City of Portland, Maine - Building or Use Permit Application
 389 Congress Street, 04101 Tel: (207) 874-8703, Fax: (207) 874-8716

Permit No: 04-1335	Issue Date:	CBL: 312 B005001
------------------------------	--------------------	----------------------------

Past Use: Commercial - legal use is professional offices on the first floor and one residential dwelling unit on the second floor	Proposed Use: Commercial install 2 Superior Boilers same footprint 2 Tanks - no change of use permitted	Permit Fee: \$111.00	Cost of Work: \$10,000.00	CEO District: 5
		FIRE DEPT: <input type="checkbox"/> Approved <input type="checkbox"/> Denied	INSPECTION: Use Group: Type	
Proposed Project Description: Commercial install 2 Superior Boilers same footprint 2 Tanks		Signature:	Signature:	
PEDESTRIAN ACTIVITIES DISTRICT (P.A.D.)				
Action: <input type="checkbox"/> Approved <input type="checkbox"/> Approved w/Condition <input type="checkbox"/> Denied				
		Signature:	Date:

ST
Floor Changes

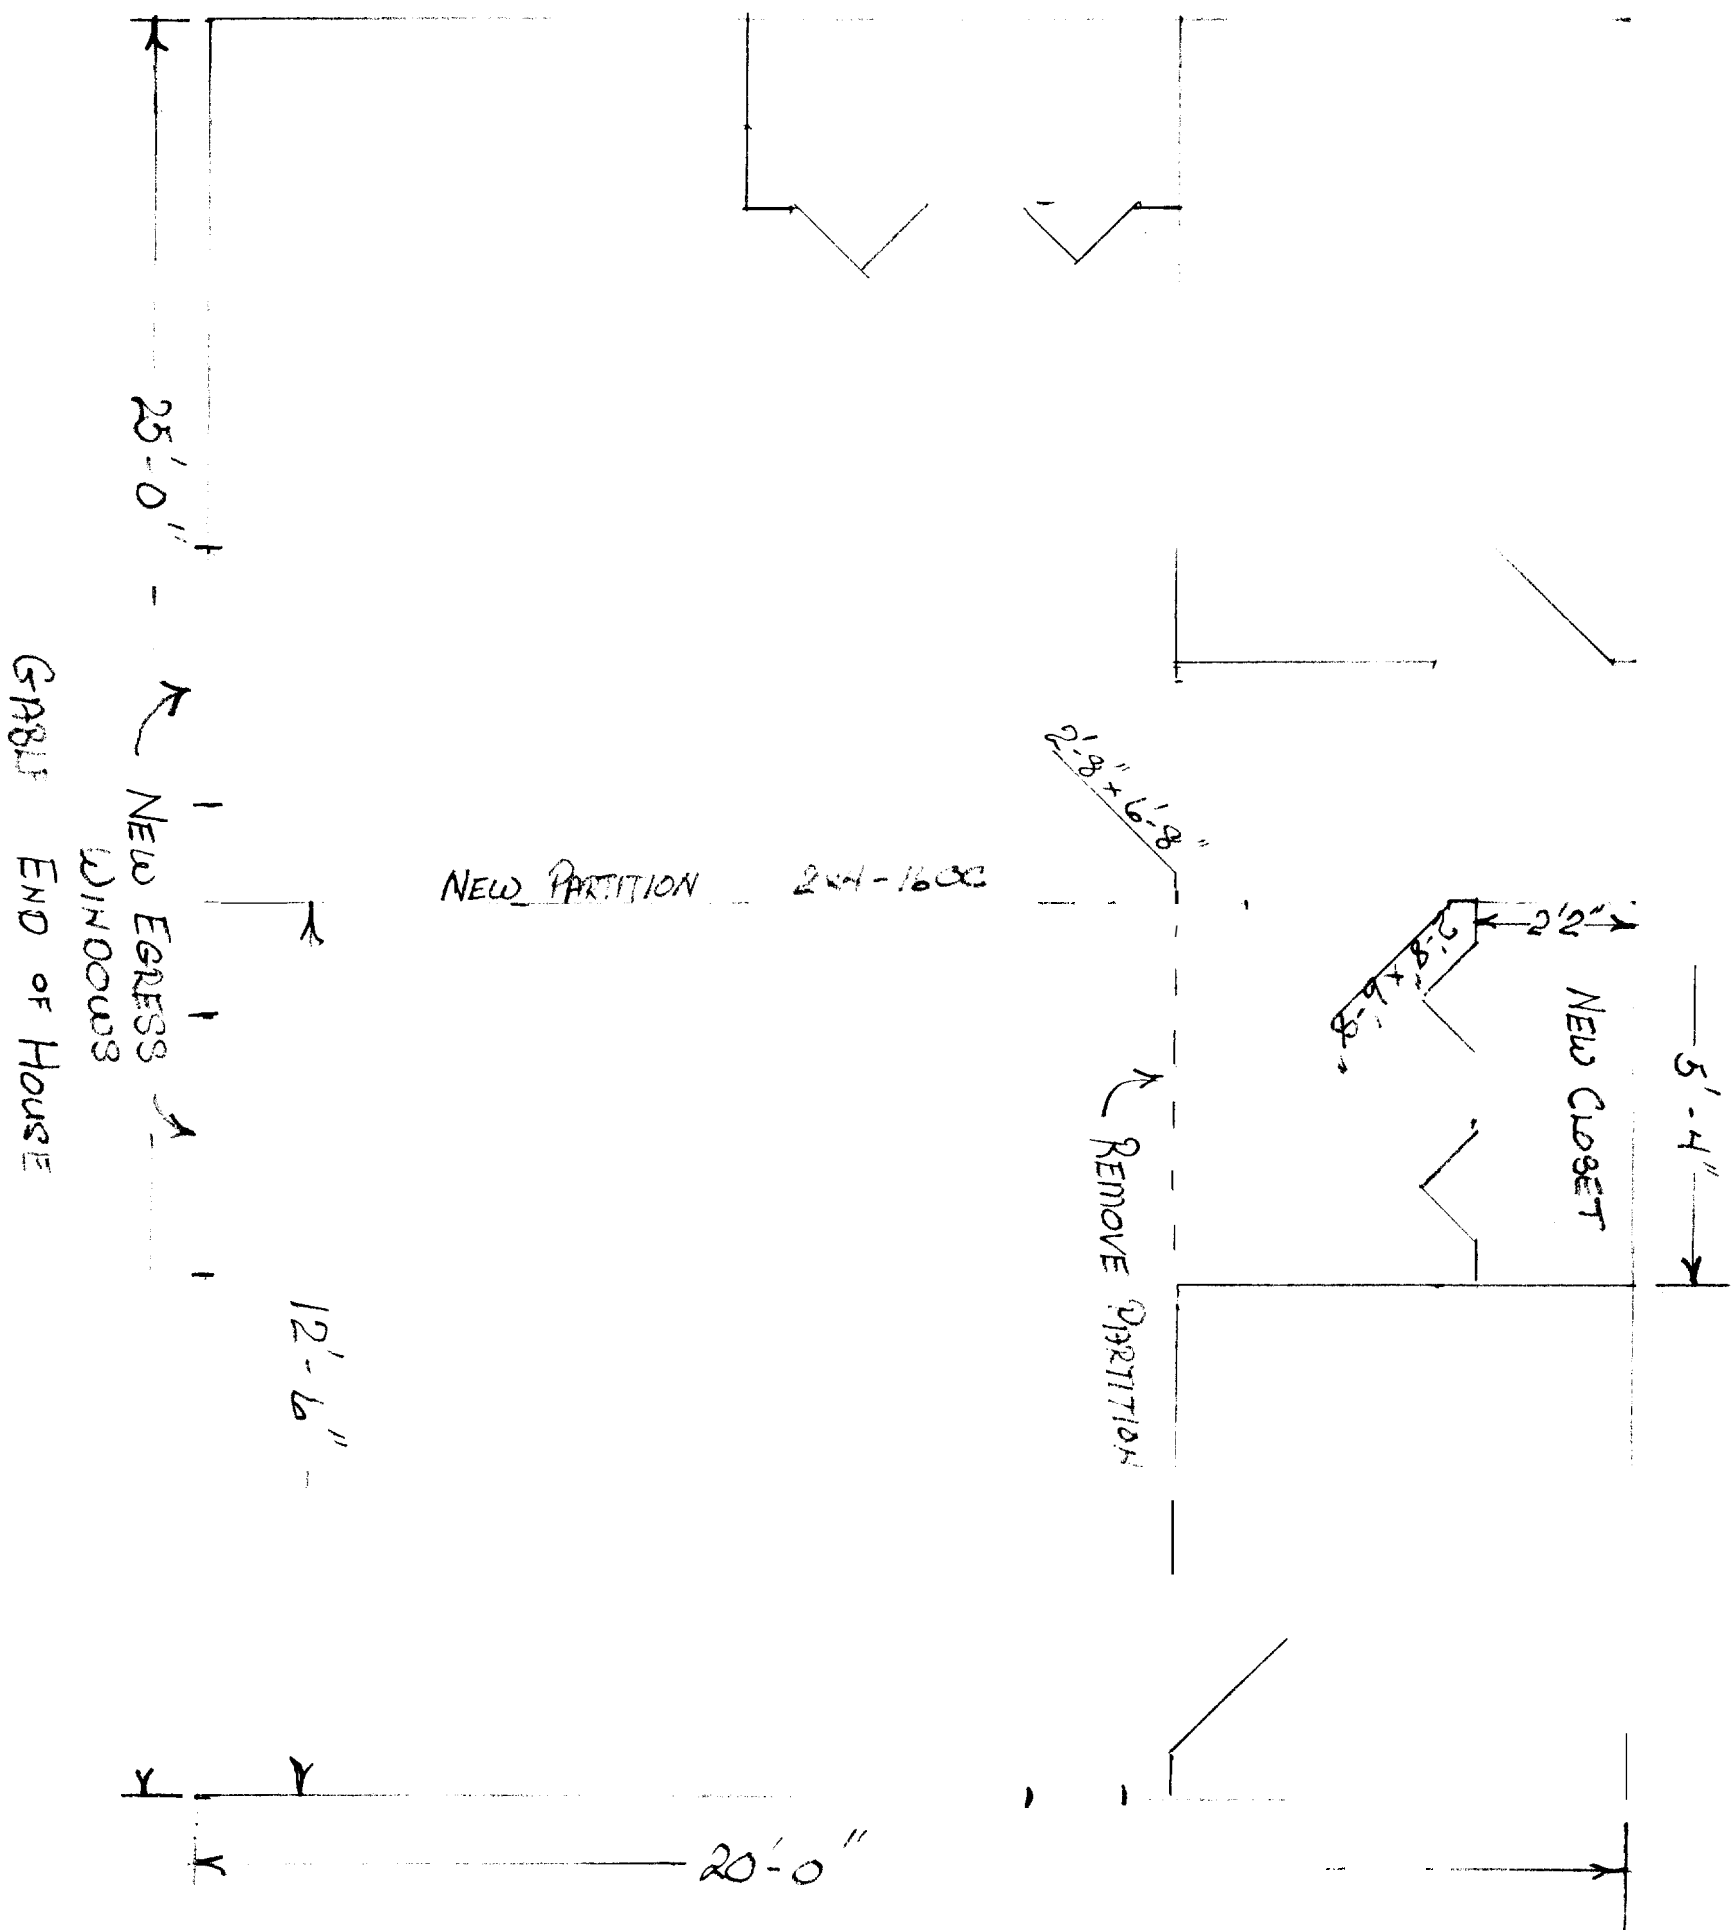
Note: 9/9/04 The residential unit on the 2nd floor is legally nonconforming - I-M Industrial zone **Ok to Issue:**

- 1) This is NOT an approval for an additional dwelling unit. You SHALL NOT add any additional kitchen equipment including, but not limited to items such as stoves, microwaves, refrigerators, or kitchen sinks, etc. Without special approvals.
- 2) This property shall remain a single family dwelling unit on the second floor with professional offices on the first floor. Any change of use shall require a separate permit application for review and approval.
- 3) This permit is being approved on the basis of plans submitted. Any deviations shall require a separate approval before starting that work.

09/14/2004-mjn: Change of use occurring with no permits....HOLD Owner advised to STOP WORK
